Norfolk Boreas Offshore Wind Farm

Statement of Common Ground

Broadland District Council

Applicant: Norfolk Boreas Limited
Document Reference: ExA.SoCG-3.D8.V3
Deadline 8

Figure 1 Proposed road regrading in proximity to the Old Railway Gatehouse

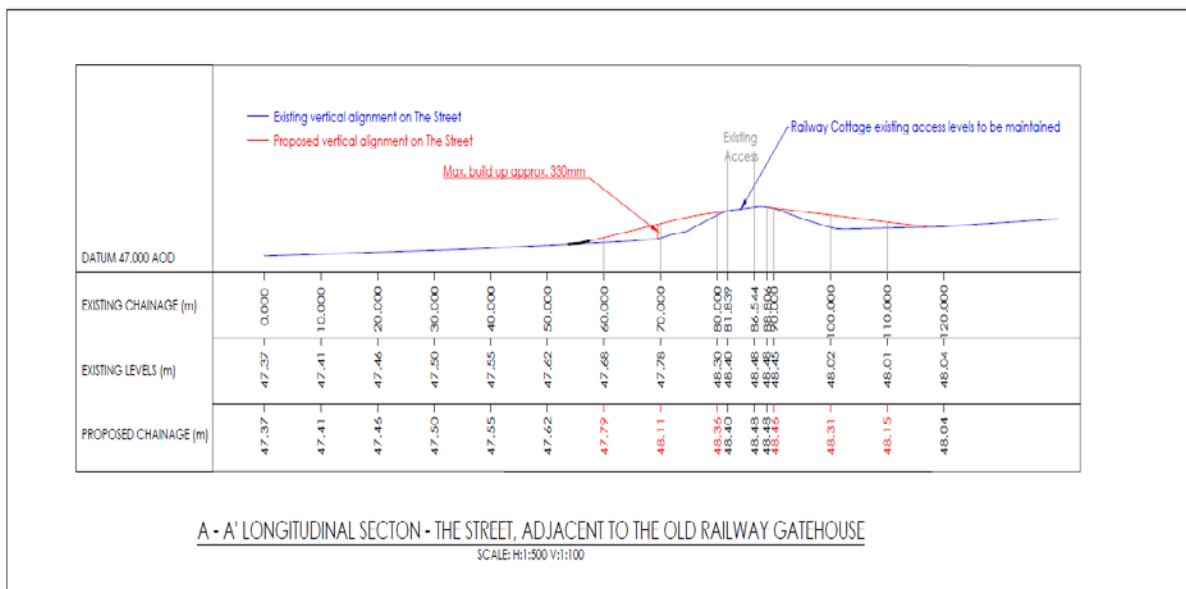
<p>Assessment findings</p>	<p>The Street, Oulton An assessment of cumulative noise, vibration and air quality effects associated with Norfolk Boreas and Hornsea Project Three along The Street at Oulton has been assessed and</p>	<p>BDC request that the physical alterations to Old Railway Gatehouse comprising new double glazing on elevations towards the road and a noise attenuation barrier to the garden form</p>	<p>The Applicant acknowledges that Broadland District Council request that the physical improvements to</p>

Topic	Norfolk Boreas Limited position	Broadland District Council position	Final position
	<p>included the Application (section 25.9 of ES Chapter 25 (APP-238) and section 26.8 of ES Chapter 26 (APP-239)).</p> <p>Further assessments specifically considering the noise, vibration and air quality effects of vehicles idling and accelerating in proximity to the Old Railway Gatehouse at Oulton was undertaken by Norfolk Vanguard and submitted during their examination at Deadline 7 (see Appendix 1). This included a cumulative effects with Hornsea Project Three.</p> <p>Mitigation was proposed in the form of a cap on the maximum number of daily HGV movements, a temporary speed restriction, regrading the road surface in proximity to the Old Railway Gatehouse, incorporation of passing places along The Street and priority warning signs in proximity to The Old Railway Gatehouse. With these mitigation measures in place residual impacts related to noise, vibration and air quality are not significant based on the agreed EIA criteria. These measures have been adopted by Norfolk Boreas and are captured within section 4.3.2 of the Outline Traffic Management Plan (OTMP) (document reference 8.8, Version 4) and secured through DCO Requirement 21.</p> <p>This combined suite of measures is consistent with those proposed by Hornsea Project Three and Norfolk Vanguard and will serve to mitigate the effects of either Norfolk Boreas or Hornsea Project Three alone, or both projects</p>	<p>part of the agreed package of measures to reduce the cumulative traffic impact of up to 3 onshore cable projects on the living conditions of the occupier.</p> <p>However, after clarification from the applicant no further assessment is required with regards to cumulative impacts.</p> <p>Agreed that the OTMP will provide sufficient controls for potential traffic related noise, vibration and air quality impacts.</p>	<p>Old Railway Gatehouse should be implemented to reduce cumulative traffic impact on the residents.</p> <p>The Applicant will look to engage with the resident to agree and implement the alterations when further details are available.</p> <p>However, the alterations are subject to the consent and agreement with the resident.</p>

Topic	Norfolk Boreas Limited position	Broadland District Council position	Final position
	<p>together. Whichever project progresses to construction first will introduce the measures and the second project will remove the mitigation at the end of construction. The scheme will be implemented under both scenarios, under Scenario 1 Norfolk Boreas will retain or reinstate the scheme from Norfolk Vanguard.</p> <p>Although the assessment has not identified the need for further mitigation, the Applicant acknowledges the potential for disturbance experienced by the residents of The Old Railway Gatehouse. As such, the Applicant has identified measures to further minimise perceived disturbance impacts comprising upgraded glazing on facades that face the traffic and a garden wall acting as a noise absorption barrier. Any proposed improvements will be subject to the consent of the property owner. These are offered as optional mitigation, to be taken forward for Norfolk Boreas Scenario 2 should the residents wish, however, they are not essential to mitigate the effects. However, the Applicant will seek to engage with resident to agree and implement the alterations where possible when further details are available. This approach is consistent with commitments also made by Hornsea Project Three and Norfolk Vanguard. For Norfolk Boreas Scenario 1 these mitigations would have been undertaken if required by Norfolk Vanguard.</p> <p>With the assessments of cumulative noise, vibration and air quality impacts along The Street at Oulton, the assessments</p>
